**WELWYN HATFIELD COUNCIL**  
**PLANNING CONTROL COMMITTEE**  
**19<sup>TH</sup> NOVEMBER 2003**  
**REPORT OF THE CHIEF PLANNING &**  
**ENVIRONMENTAL HEALTH OFFICER**

**S6/03/380/FP**  
**CONVERSION OF EXISTING ACCOMMODATION BLOCK AND**  
**HANGER, TO TWENTY FOUR RESIDENTIAL UNITS AND CAR PARKING**  
**ASTWICK MANOR, COOPERS GREEN LANE, HATFIELD**

Scale	Date	Drawn	No.	Rev.
1:500	FEB 2003	ID	4274/52

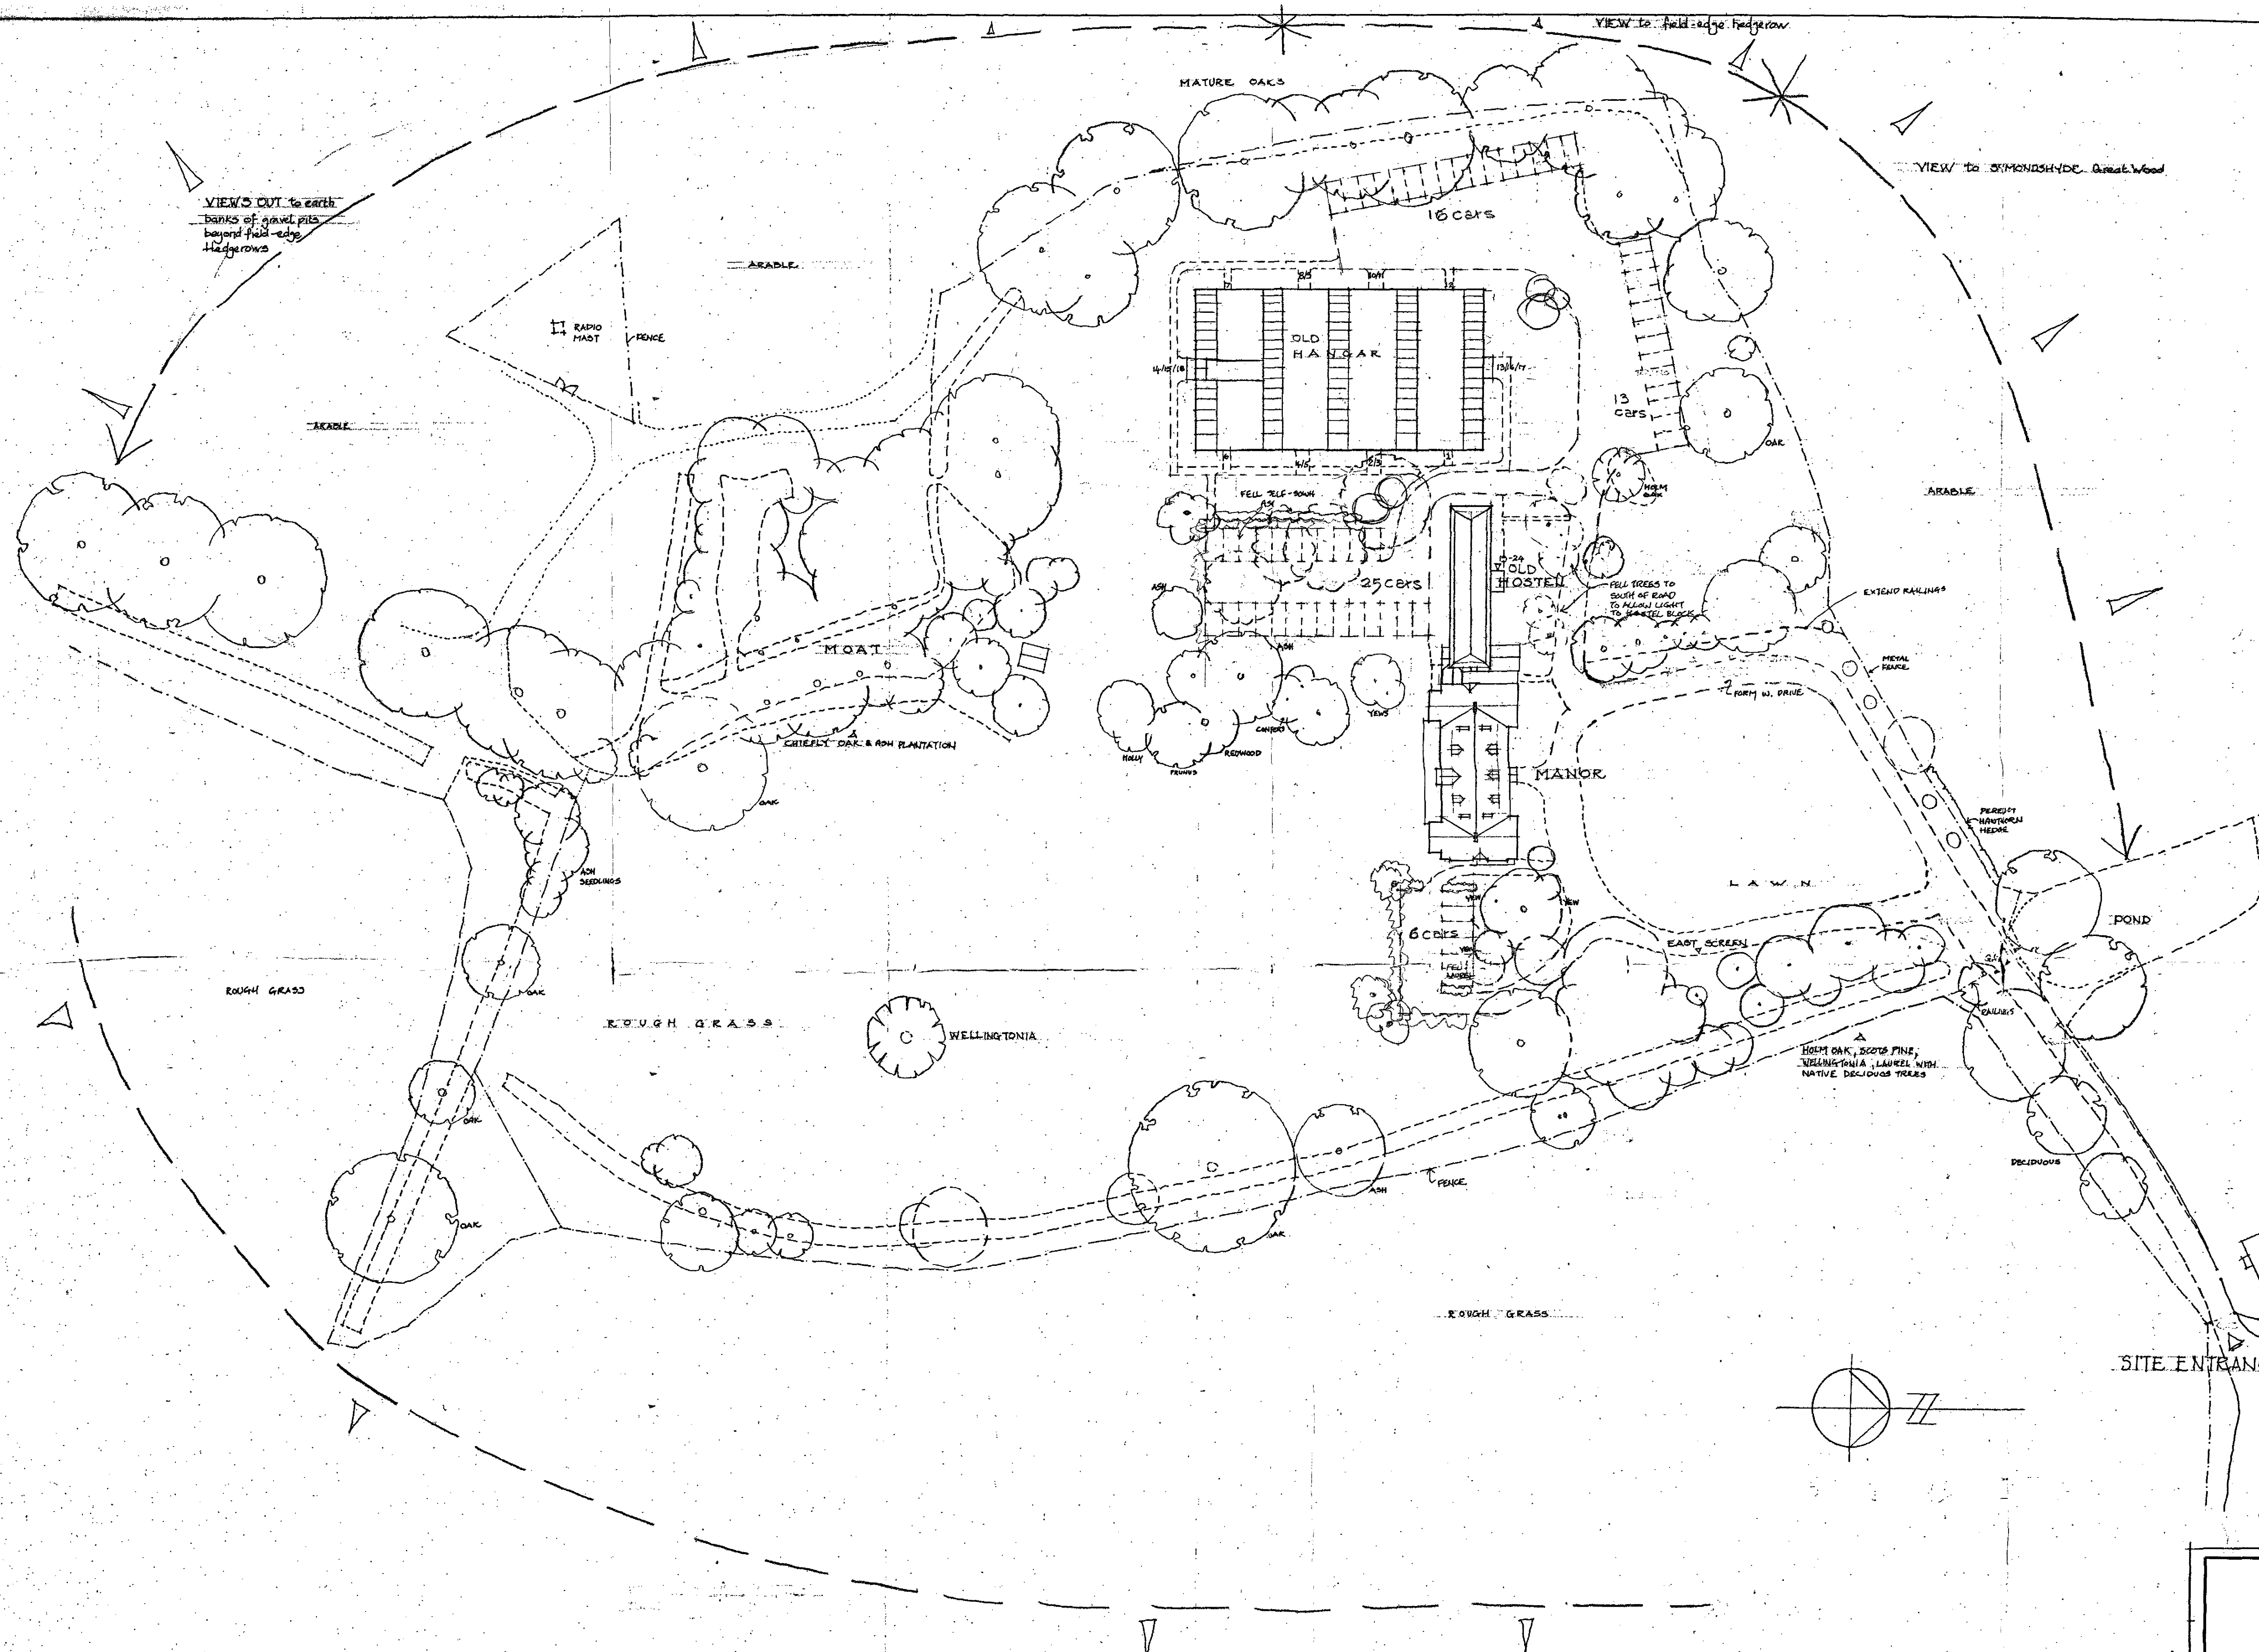
8.5 Notwithstanding the details of the car parking layout on the site, shown on drawing 4274/52, prior to the commencement of development there shall be submitted to and agreed in writing by the LPA a revision to those details which shall show a less formalised approach to the car parking provision. Once agreed the revised car parking details shall be laid out as such and made available for use prior to the occupation of the buildings. The car parking provision shall subsequently be retained and made available for use at all times that the buildings are in use for the permitted purpose.

Notwithstanding the details set out on drawing number 4274/52 no railings shall be erected to the west of the new element of the driveway to be created until the location of them has been submitted to and agreed in writing by the LPA. Once agreed the location of the railings shall be as such.

Scale	Date	Drawn	No.	Rev.
1:100	FEB 2003	1D	4274/55	A

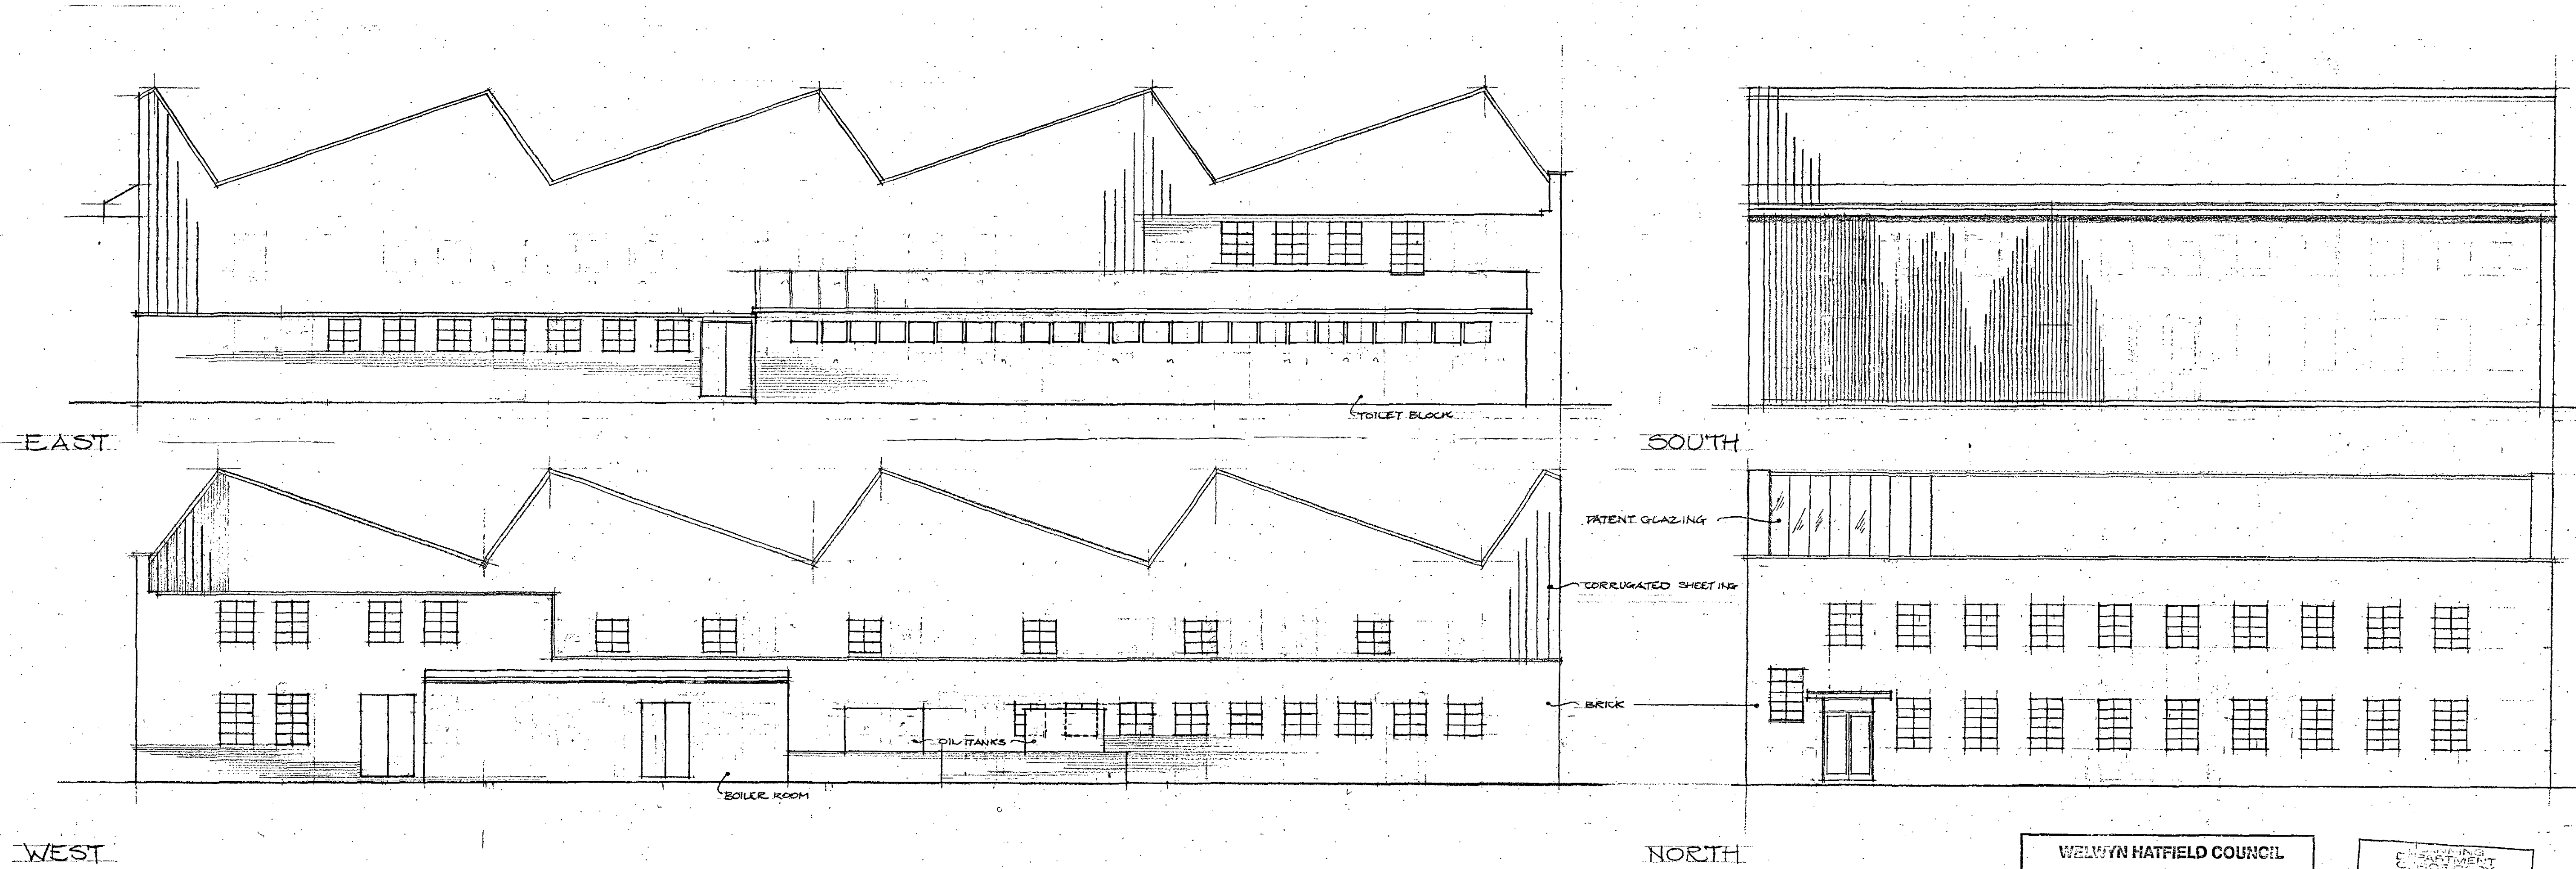
8.4 Notwithstanding the details of the design of the new entrance feature for the accommodation block, shown on drawing no 4274/55A, prior to the commencement of the development there shall be submitted to and agreed in writing by the LPA details of a revision to the design of that feature. Once agreed the proposals shall be implemented as such.
